January 26, 2023

RE: COA Pino Yards New Salt Storage Dome
5501 Pino Ave. NE
Grading and Drainage Plan
Engineer's Stamp Date: 1/16/2023
Hydrology File: D18D002D

Based upon the information provided in your submittal received 1/17/2023, the Grading & Drainage Plan is **not** approved for Building Permit. The following comments need to be addressed for approval of the above referenced project:

SHEET NO:  
**C-1**

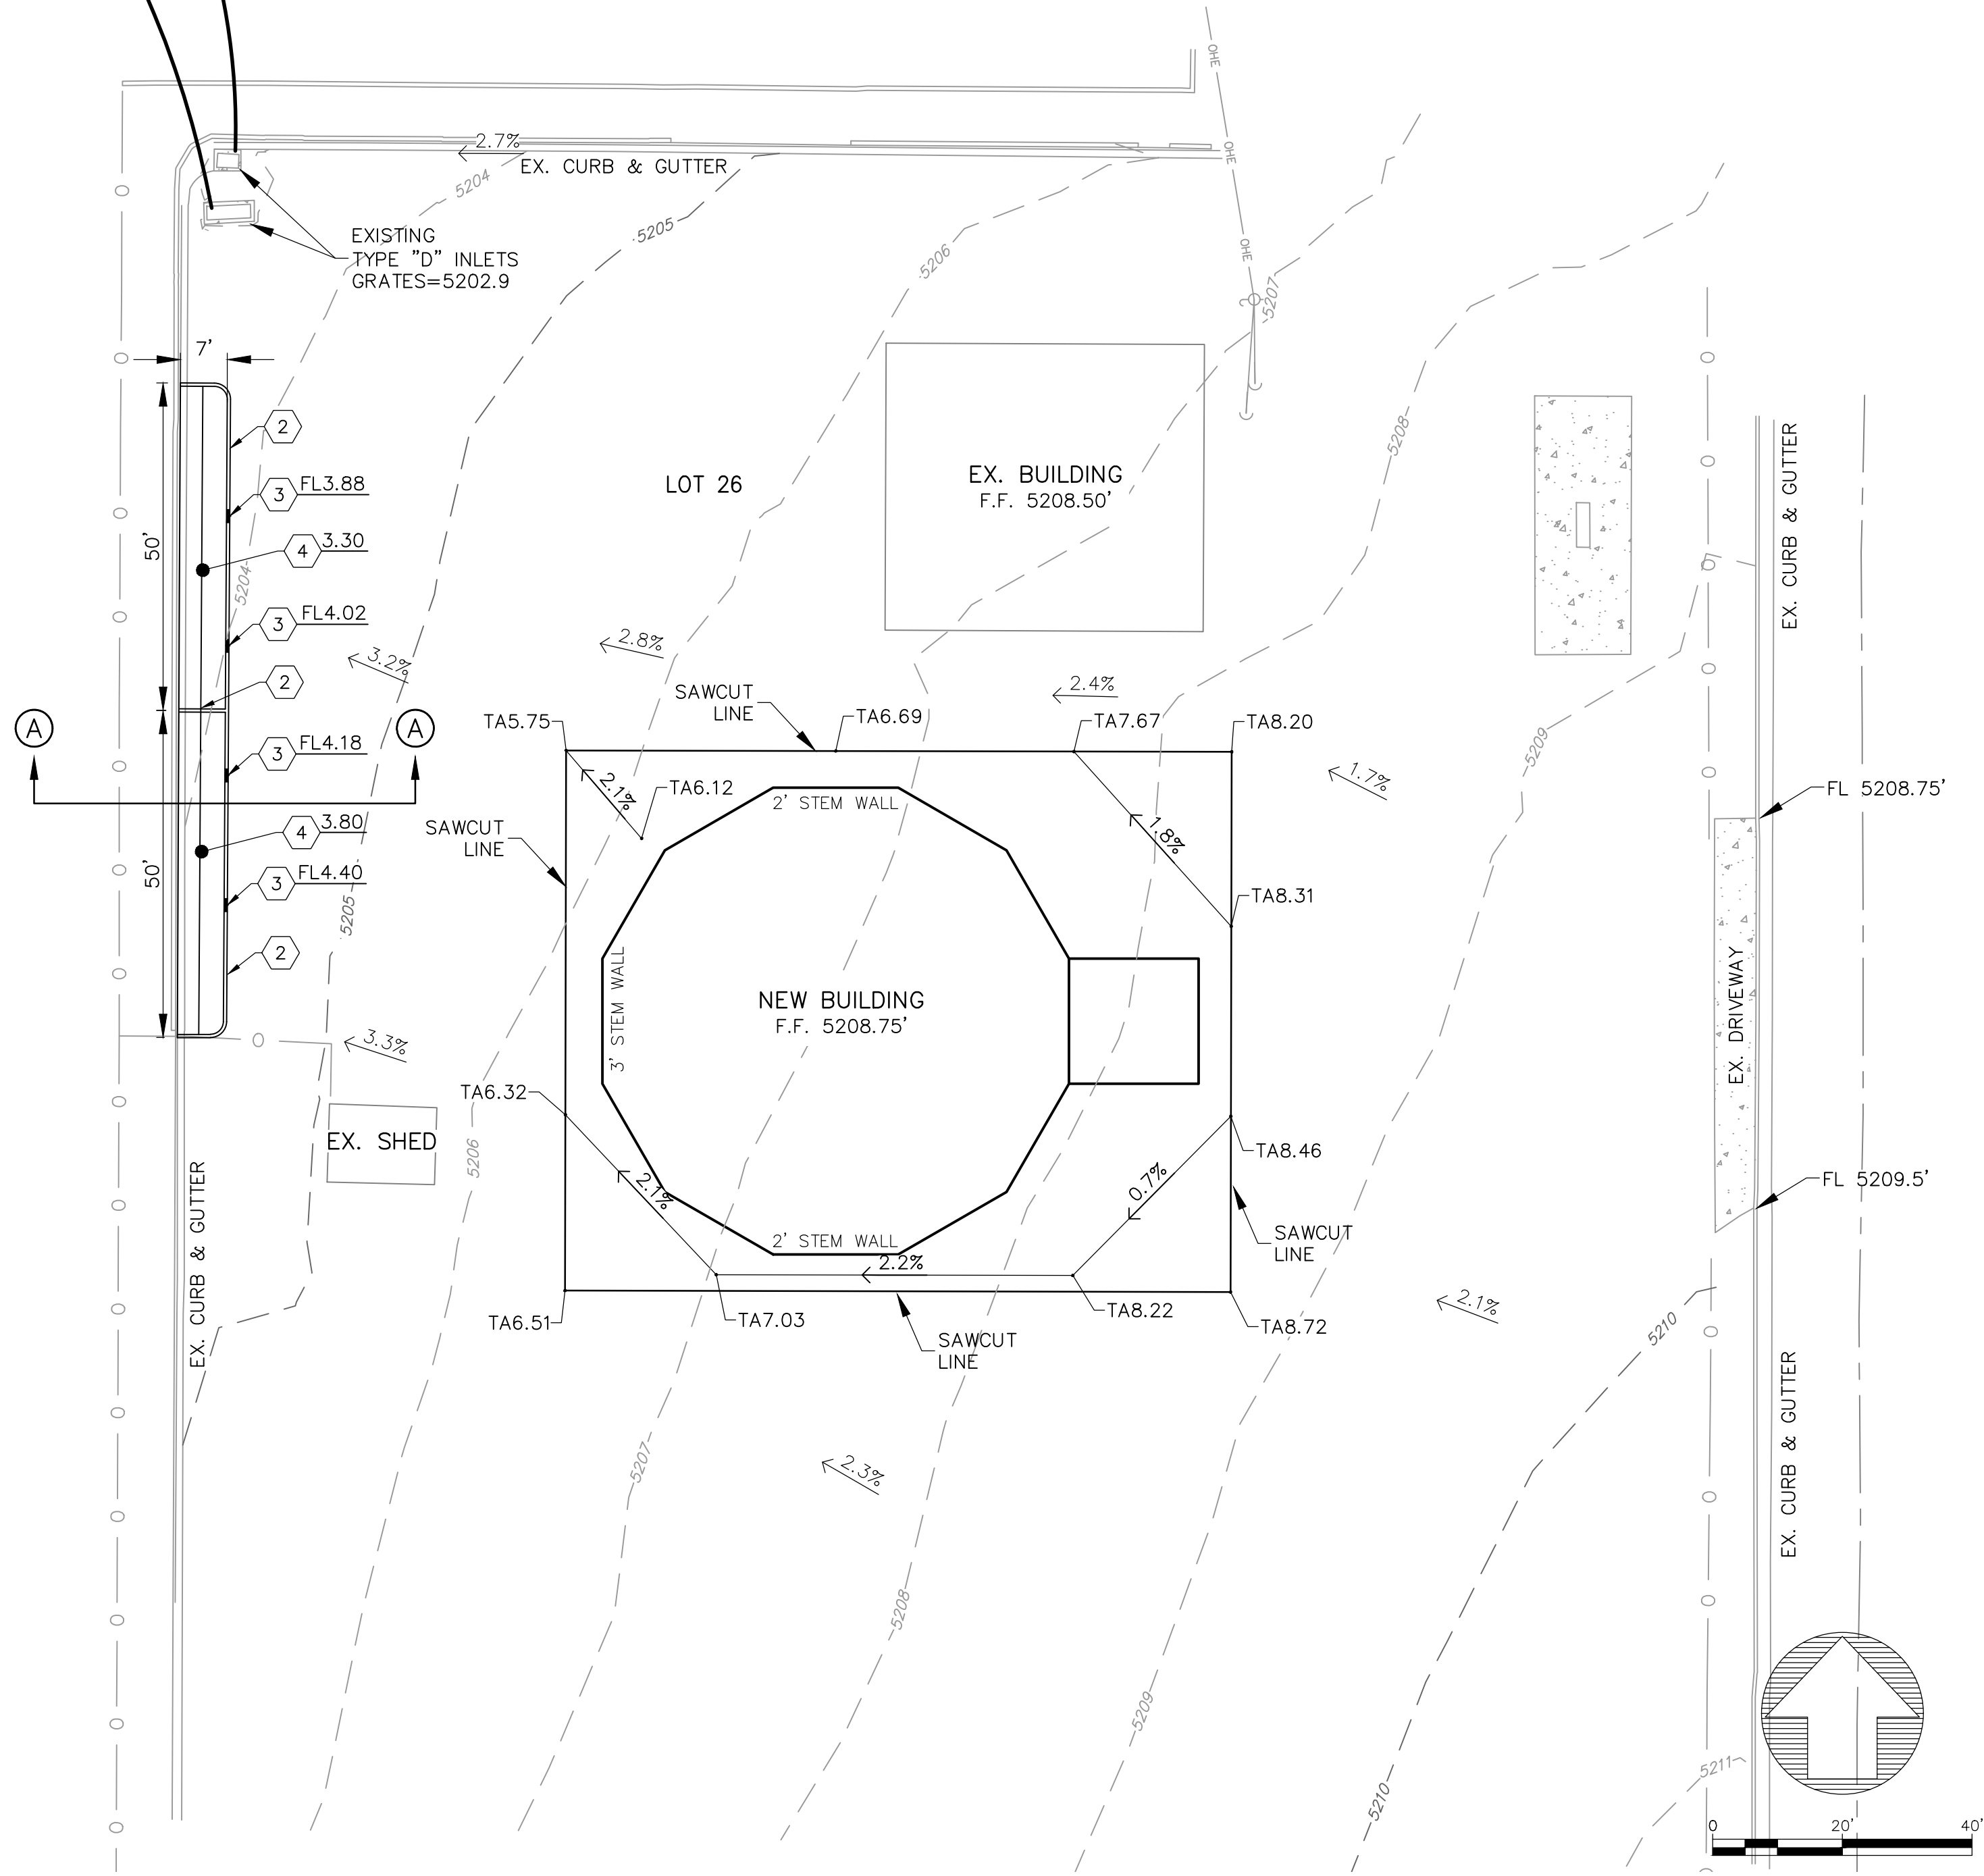
1. Please provide the SWQV pond volume calculations. Add a spillway to the north. It is recommended to make this pond a retention pond. Otherwise, a Multi-Sector General Permit (MSGP) for Industrial Stormwater Discharge maybe required by the EPA. Contact Shellie Eaton (768-2774) at the City of Albuquerque DMD for more information.
2. Are those 6" head curbs necessary? If so, please change the curb height in the typical curb opening detail to 6".
